KITTTITAS COUNTY COMMUNITY DEVELOPMENT SERVICES

RE: Richard Short Plat, File #SP-07-15

The Kittitas County Community Development Services Department has determined that the Richard Short Plat is a complete application and hereby grants **conditional** preliminary approval subject to the following conditions:

DVN. BY	KJW	DATE	12/01/06	JOB NO.	00731.019
CHKD. BY	JMB	SCALE	VARIABLES	SHEET	2 OF 2

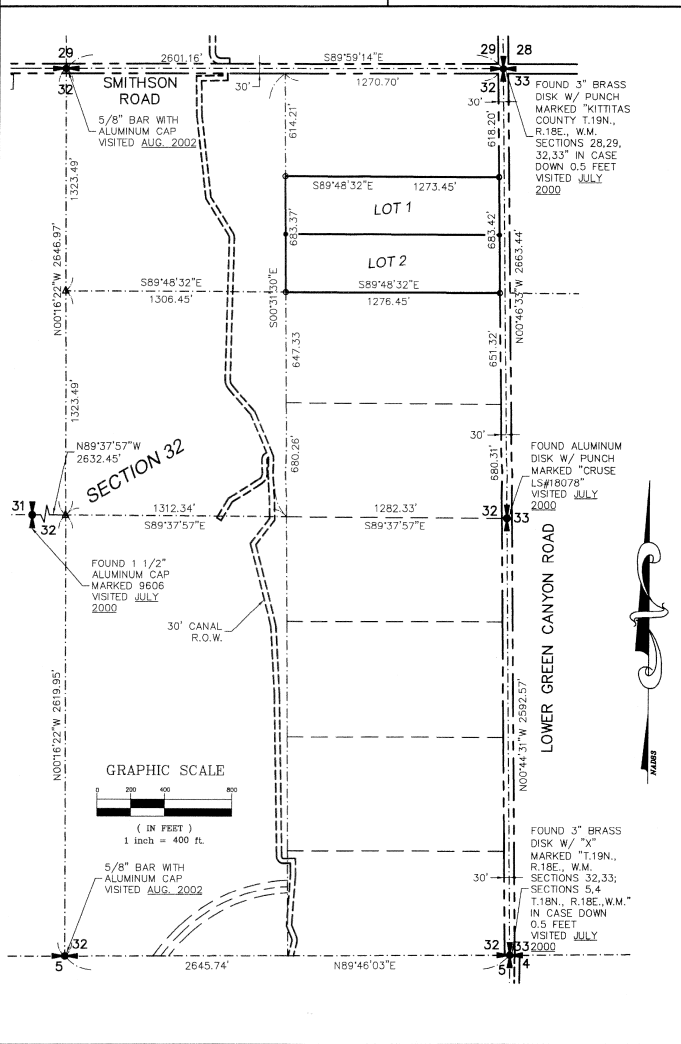
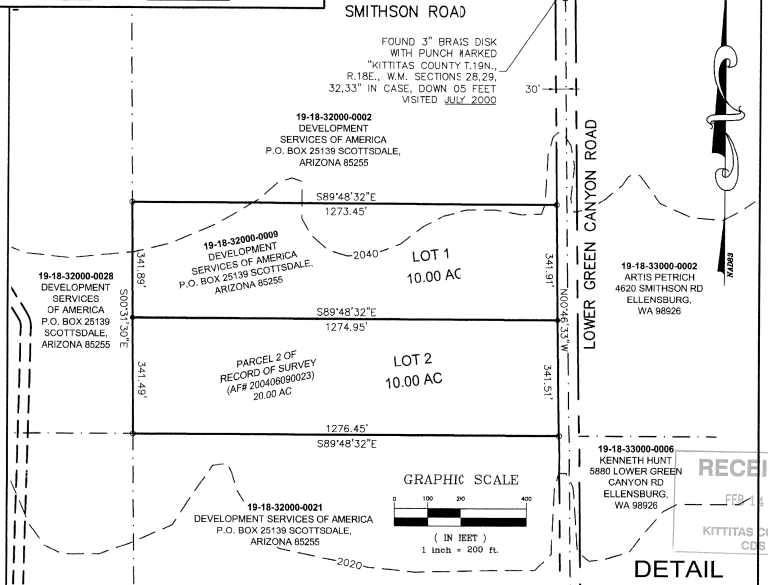
1. Both sheets shall reflect the short plat number SP-07-15.
2. Both sheets shall have location of subdivision by section, township, range, county, and state.

3. Page one shall reflect the short plat map.
4. A statement regarding the contemplated sewage disposal, water supply, and drainage improvements for the proposed subdivision shall be reflected on the final mylars.

5. Vicinity map showing the boundary lines of all adjacent subdivisions shall be reflected on the final mylars.
6. This property is within the boundaries of the KRD and both parcels contain irrigable ground. The applicant will need to comply with the requirements set forth in the KRD General Guidelines prior to approval from KRD and prior to final approval of the short plat.

10. Both lots of the Richard Short Plat have a PEMC wetland across the west end of the property. The Final mylars shall reflect the location of this wetland and a statement on the plat shall read as follows: "Future development of lots may require a study by a certified wetland biologist to determine wetland classification and for buffer requirements pursuant to KCC Critical Areas Code."
